**RE: SITE PLAN – ADMINISTRATIVE DEVELOPMENT FACILITATION TEAM
PR-2024-010691, SP-2025-00031
7520 RAINBOW BLVD NW; LT 11-A BLK 2 PLAT OF LTS 10-A, 11-A, 19-A THRU 22-A BLK
2 UNIT 14 VOLCANO CLIFFS SUBD CONT 2.0312 AC**

Please see responses to DFT comments for **PR-2024-010691, SP-2025-00031**.
Also included are the updated construction drawings to address the comments.

2
A201
EXTERIOR ELEVATION & PROFILE PLAN - WEST
SCALE: 1" = 10'-0"

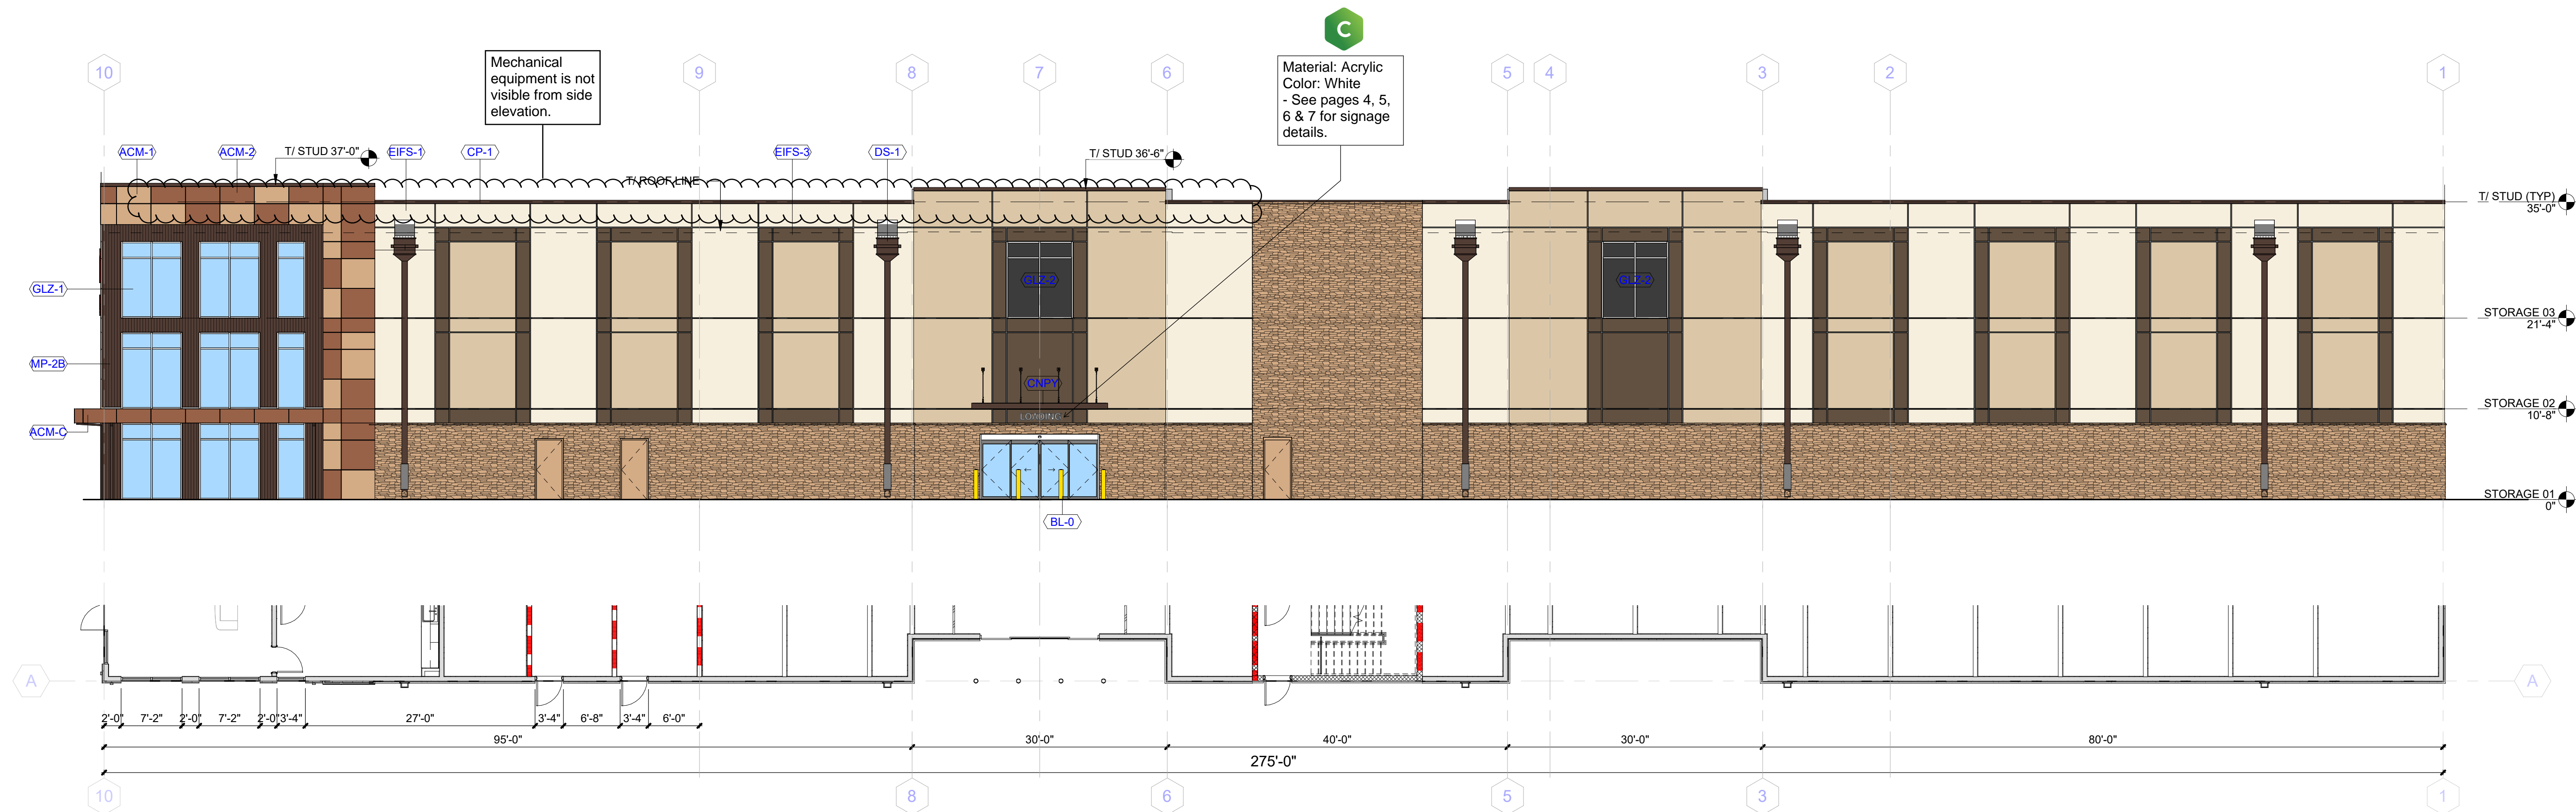
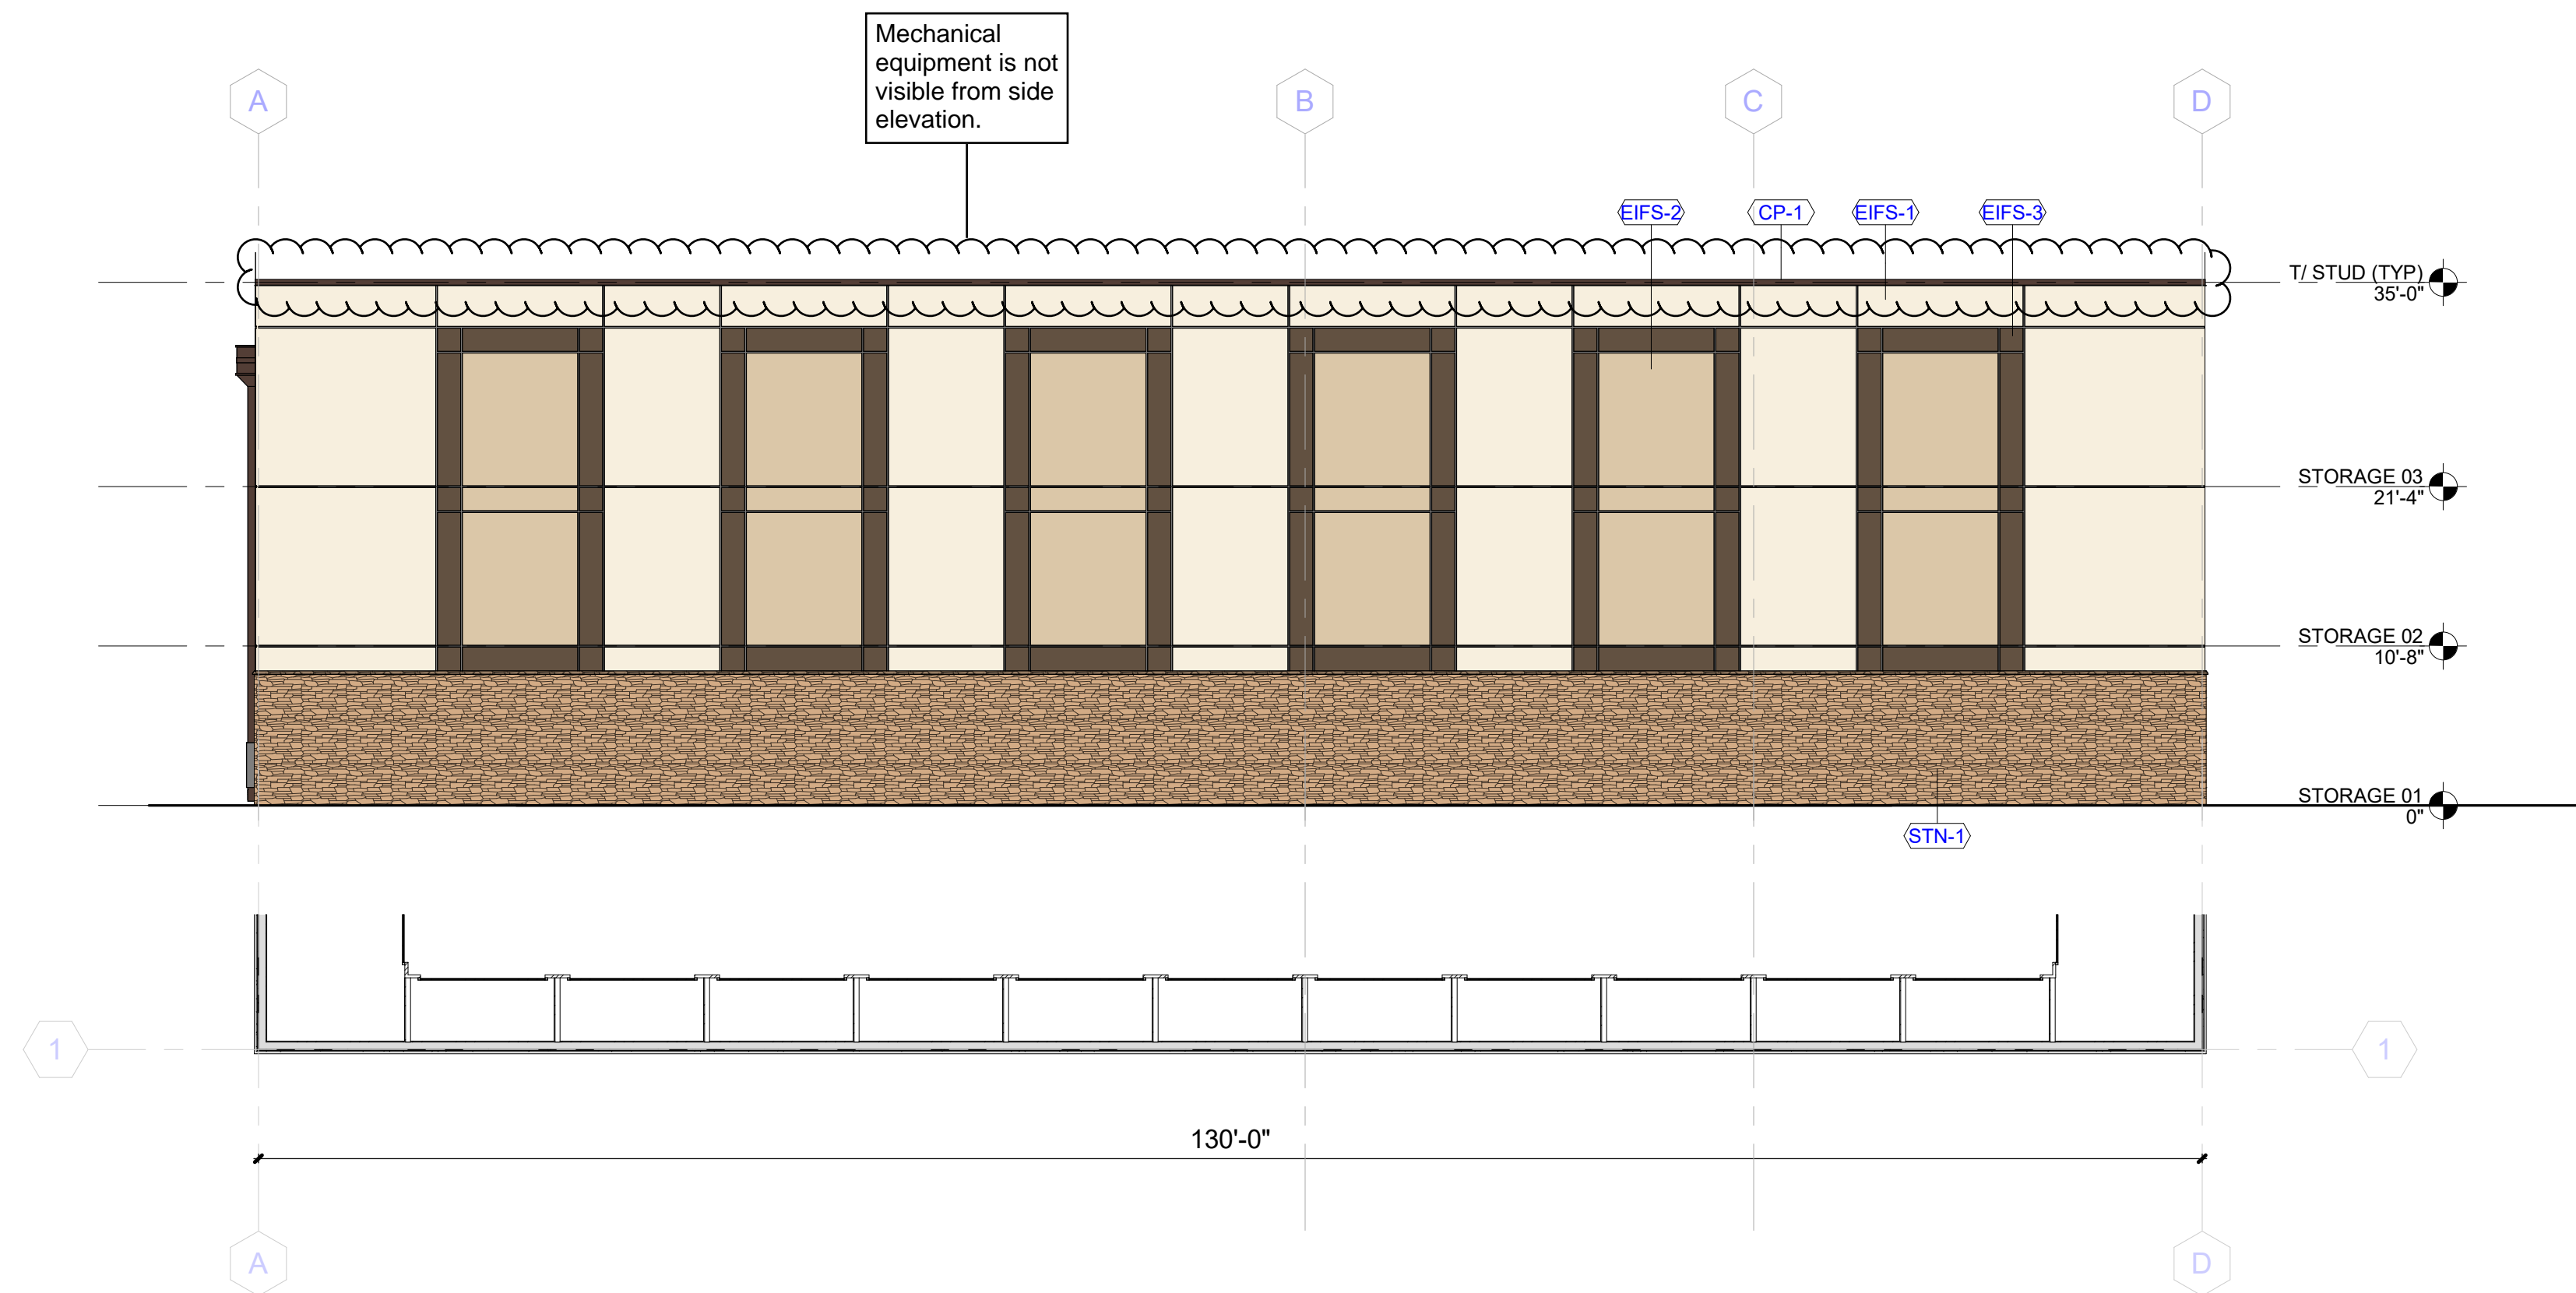
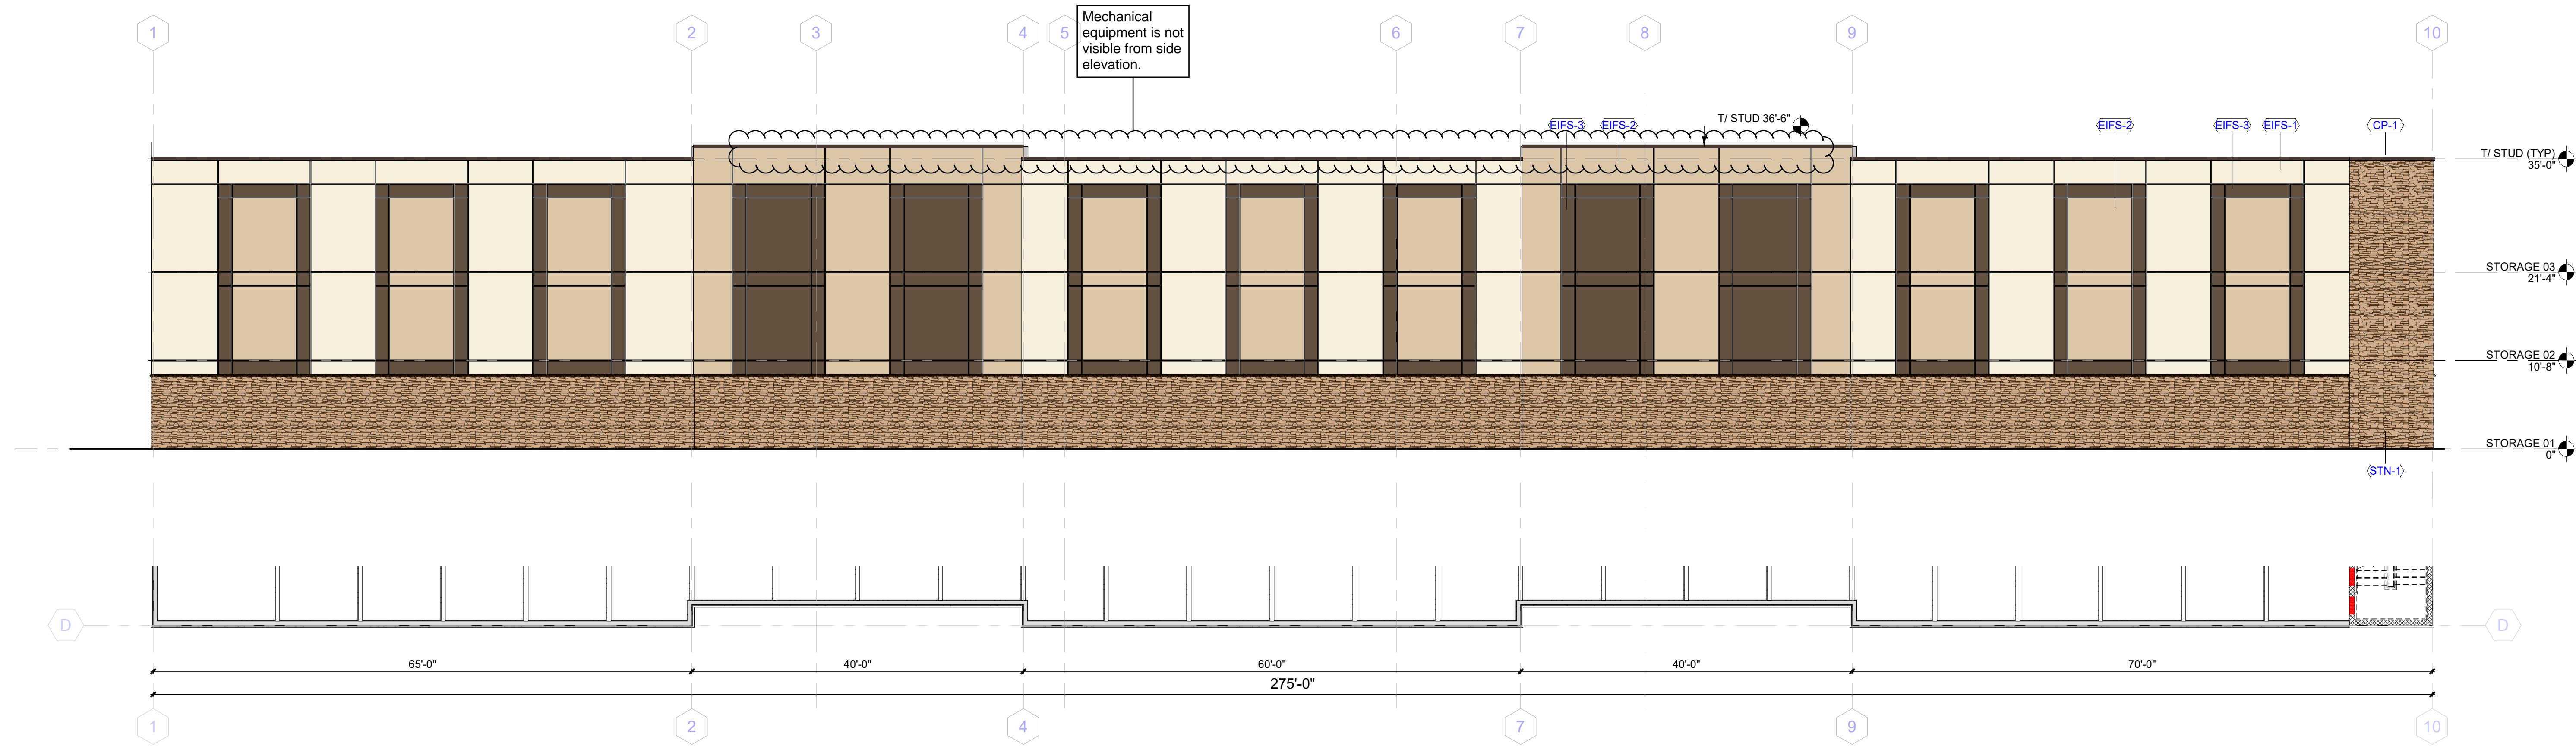
15. Elevation pages need to include details on how the project will be meeting IDO section 3-6-(E) Northwest Mesas Escarpment; specifically, 6-6(E)(5). Provide additional elevation detail to demonstrate and explain compliance with all sections within 5-11-E. Specifically 5-11-(E)(2) and 5-11(E)(3)(a)(2).

RESPONSE: See updated Elevation sheets highlighting color pallet from section 3-6(E)(5). All dimensional standards in section 3-6-(E), 5-11-(E)(2), and 5-11(E)(3)(a)(2) are met, see dimensions.
